**2015 Financial Assurance
Estimate Form**

PPR1846

Project Information	
The Townhomes at Bradley Crossroads	2/14/2019
Project Name	Date

GRADING & EROSION
CONTROL PLAN
GRADING PLAN (NORTH)

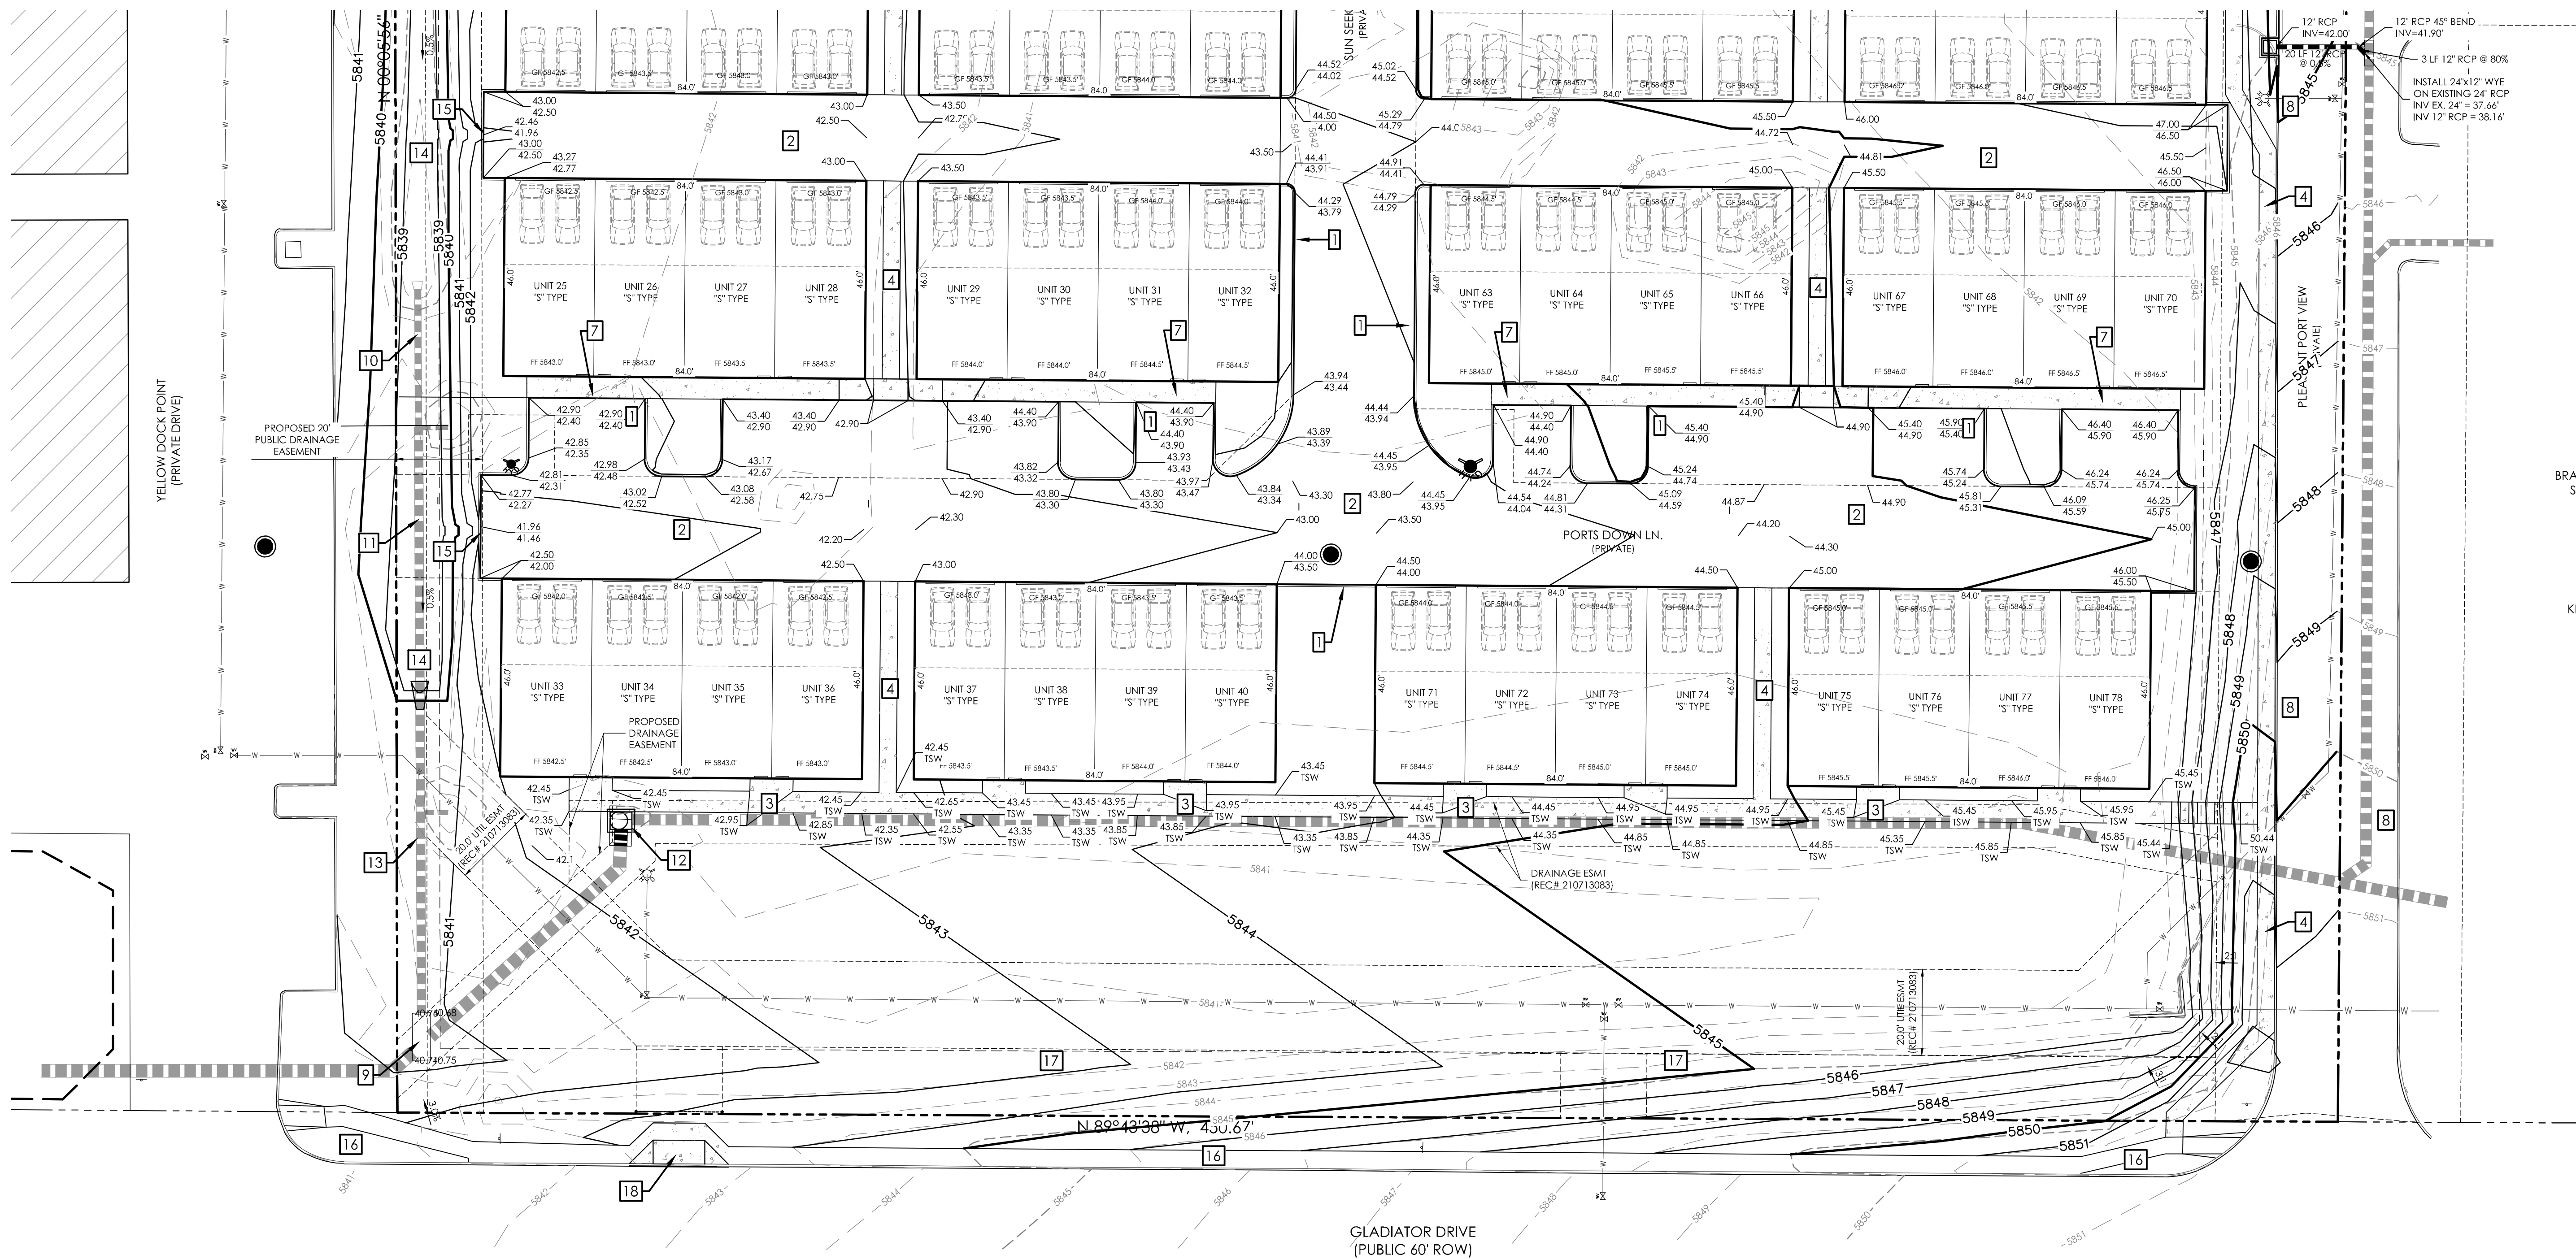
Review 2: 6 inlet protection are shown on the GEC plan. Revise.

Review 3: Unresolved
